To Department of Planning, Housing and Infrastructure

3 September 2025

Re; West Culburra Mixed Use Subdivision Modification (SSD-3846-Mod-1

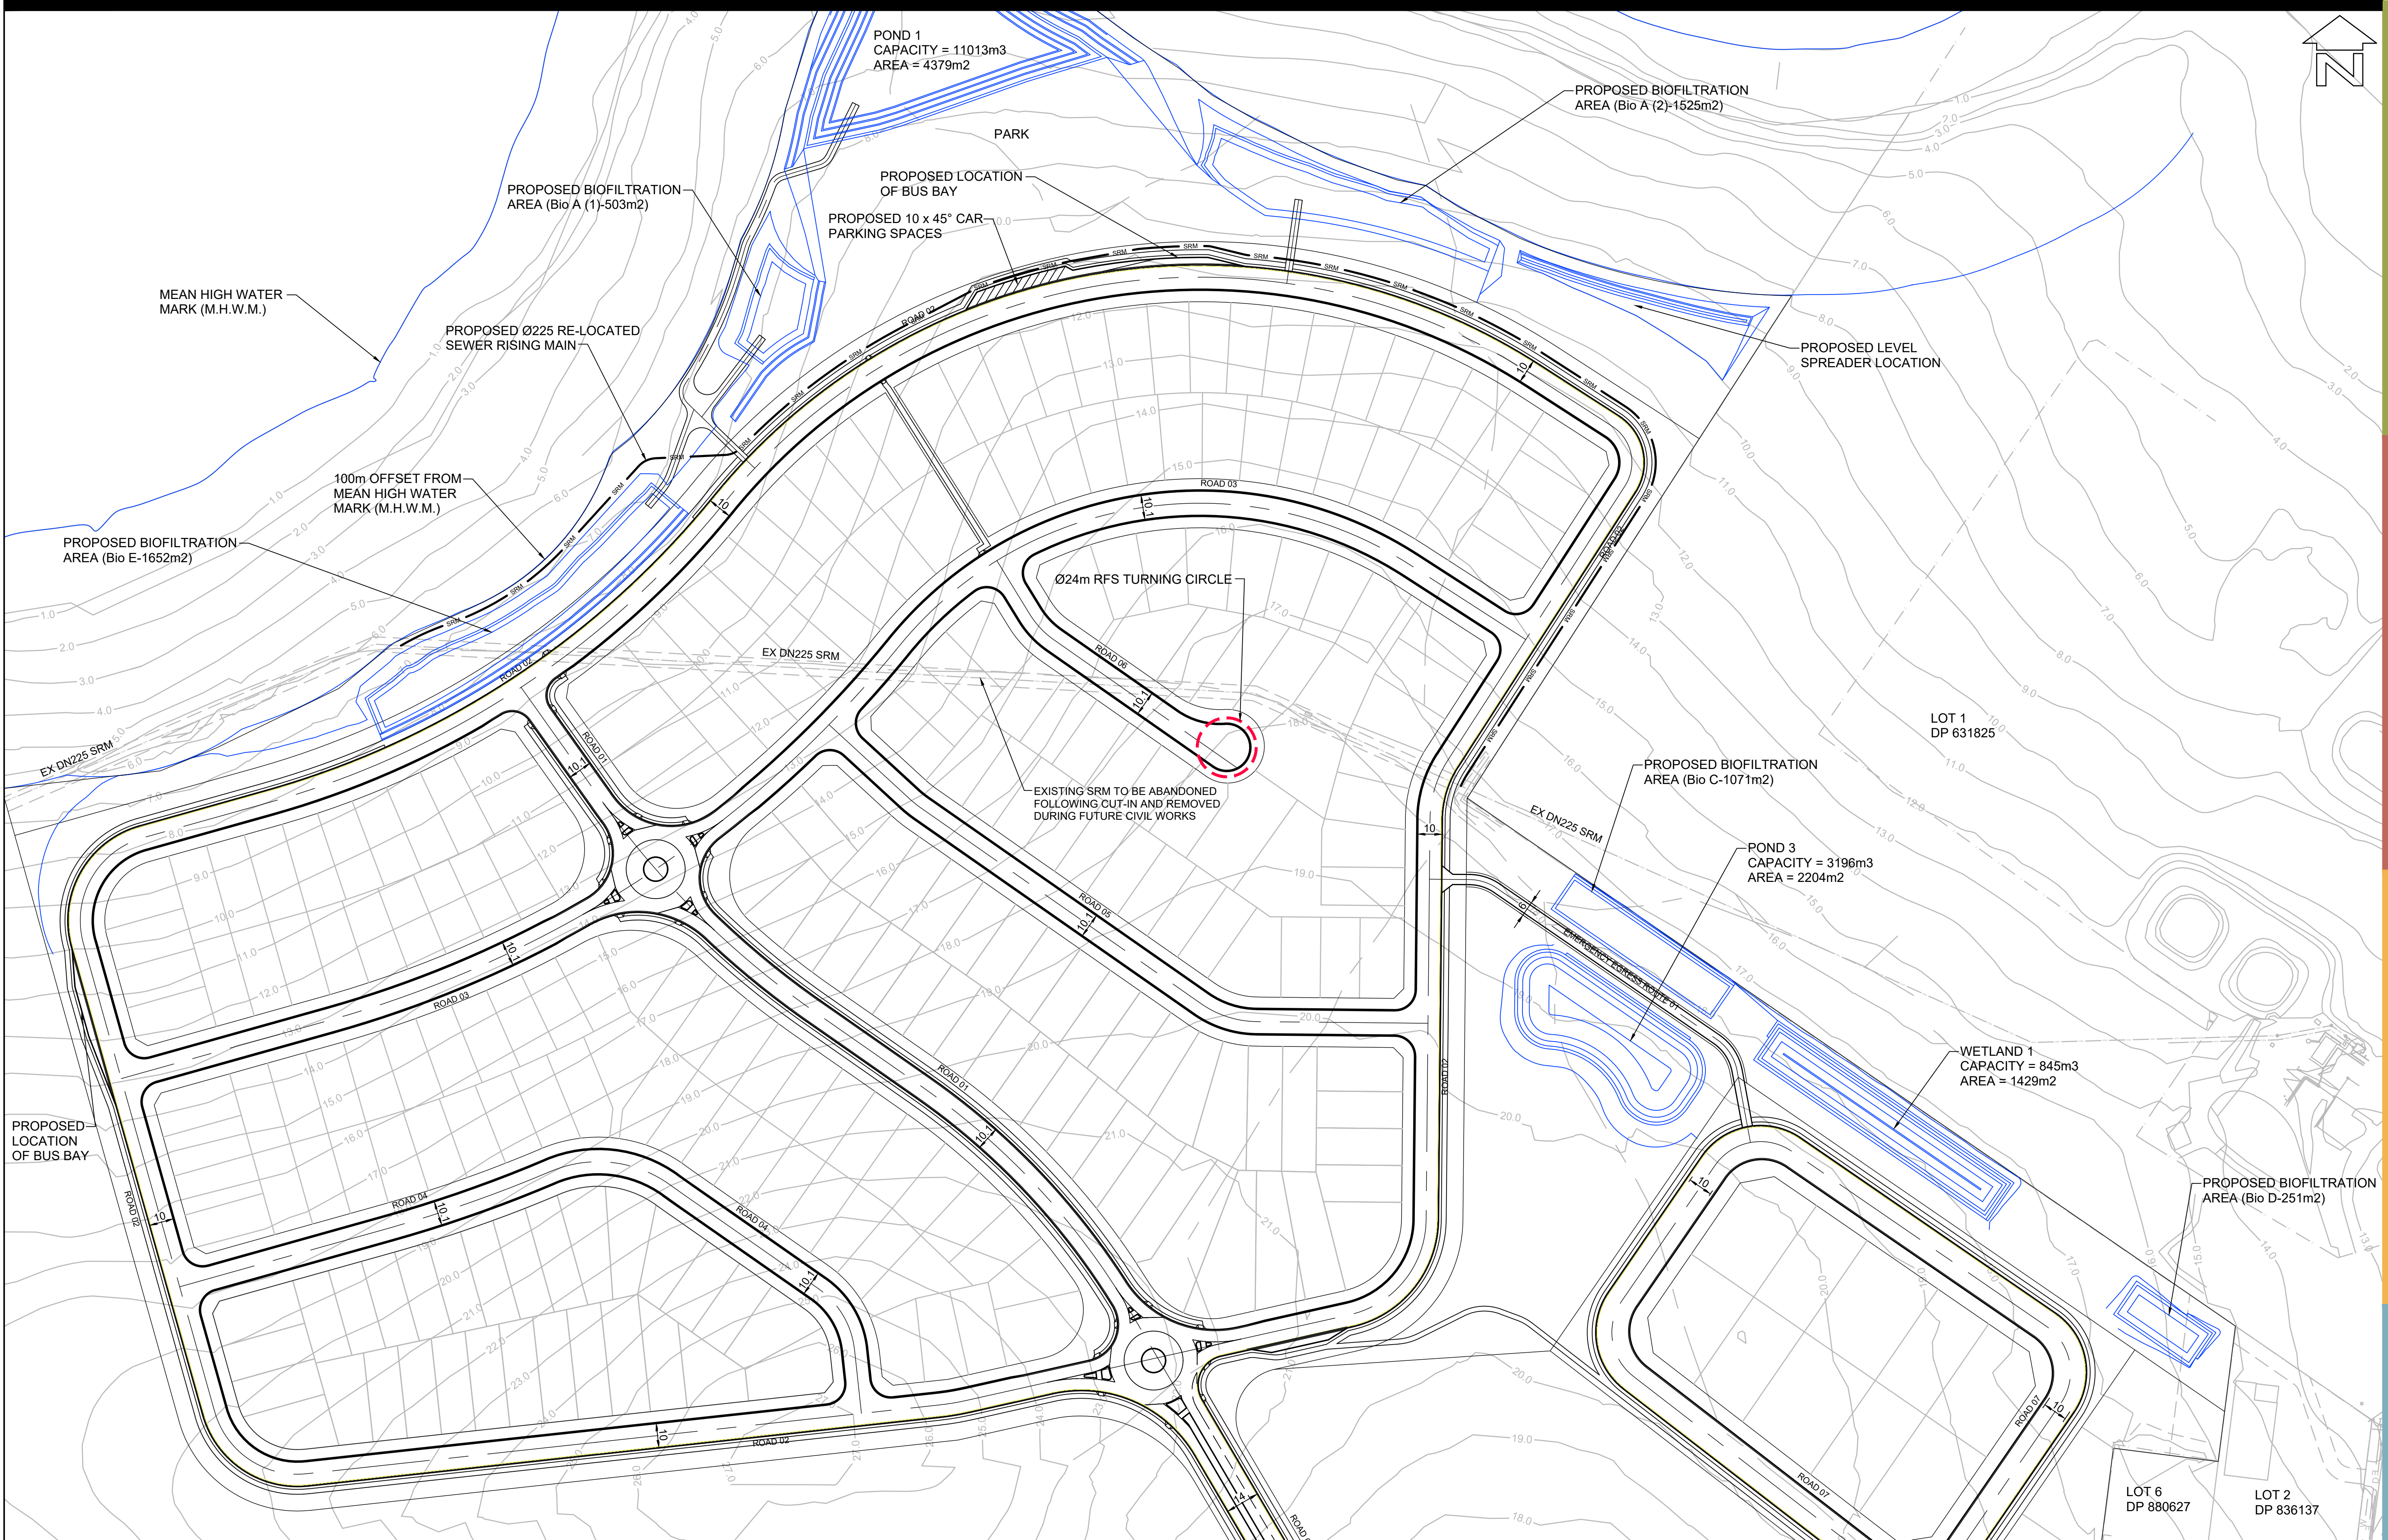
What is structure opposite the entry Road in Lot 5(c) ?
